Paul Cann
Senior Engineer (Drainage & Coastal)

APPLICATION **A/114/17/PL**

Site Address: Highway Outside Hangleton Nursery Hangleton Lane Ferring
BN12 6PP

Description of Works: To widen a section of Hangleton Lane adjacent to the vehicle storage compound to ease access onto the site for transporter vehicles. This application is also within the parish of Ferring.

DITCH CULVERTING WORKS Scale 1:25

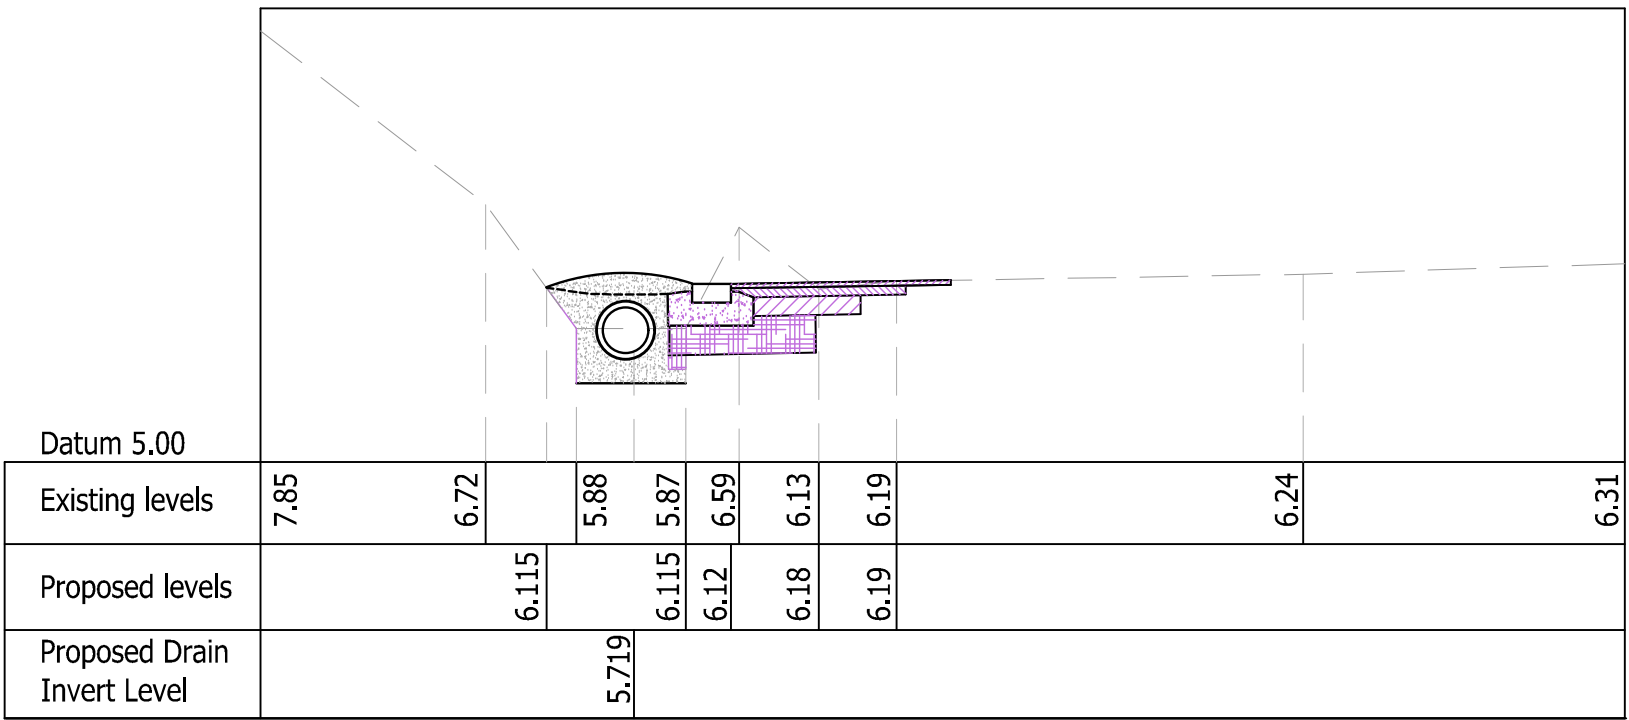
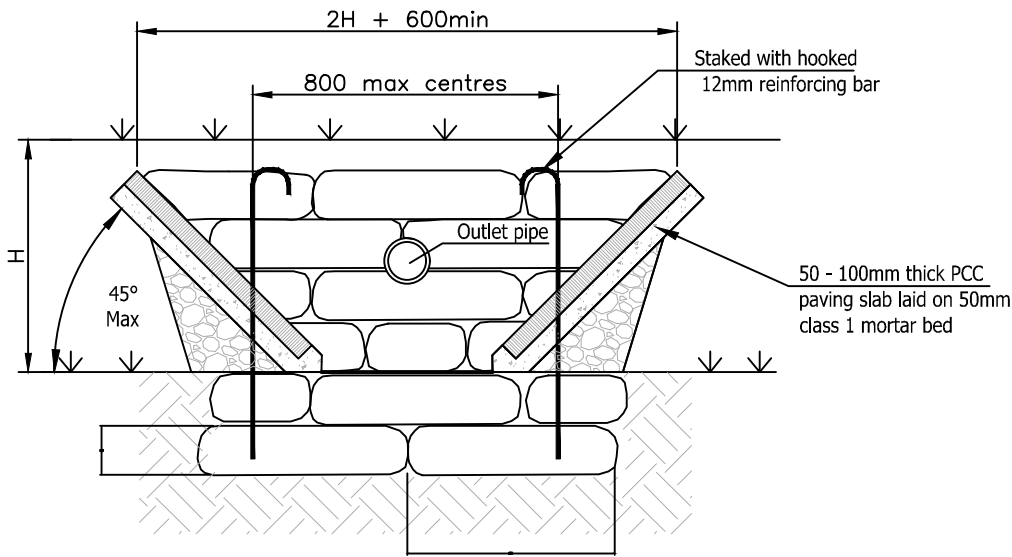
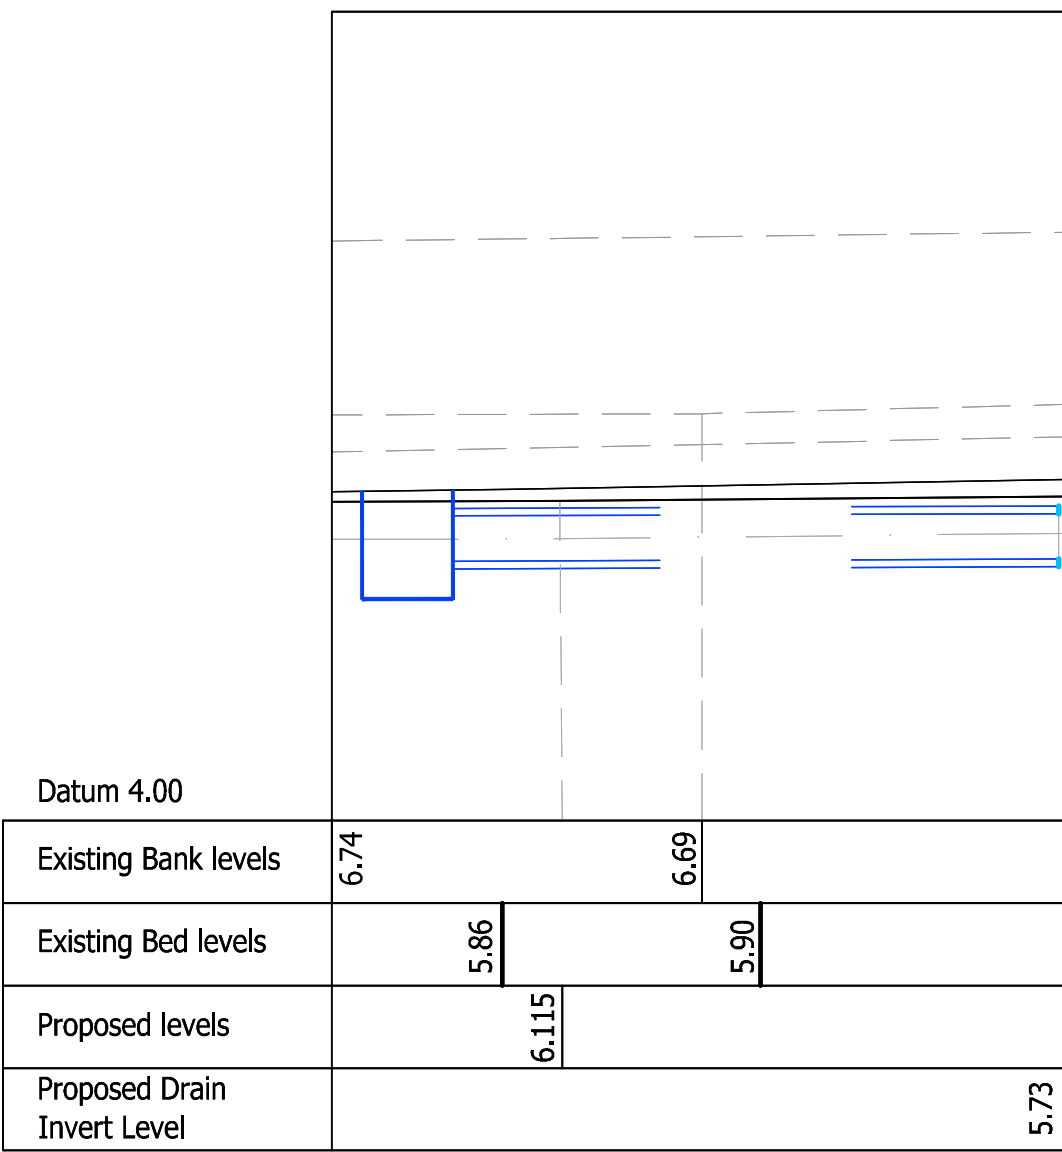
Land drainage consent will be required for any alteration to the existing watercourse.

Bearing in mind the existing flooding issues in this vicinity, it is imperative that the proposals do not make things worse. Betterment should be sought where possible.
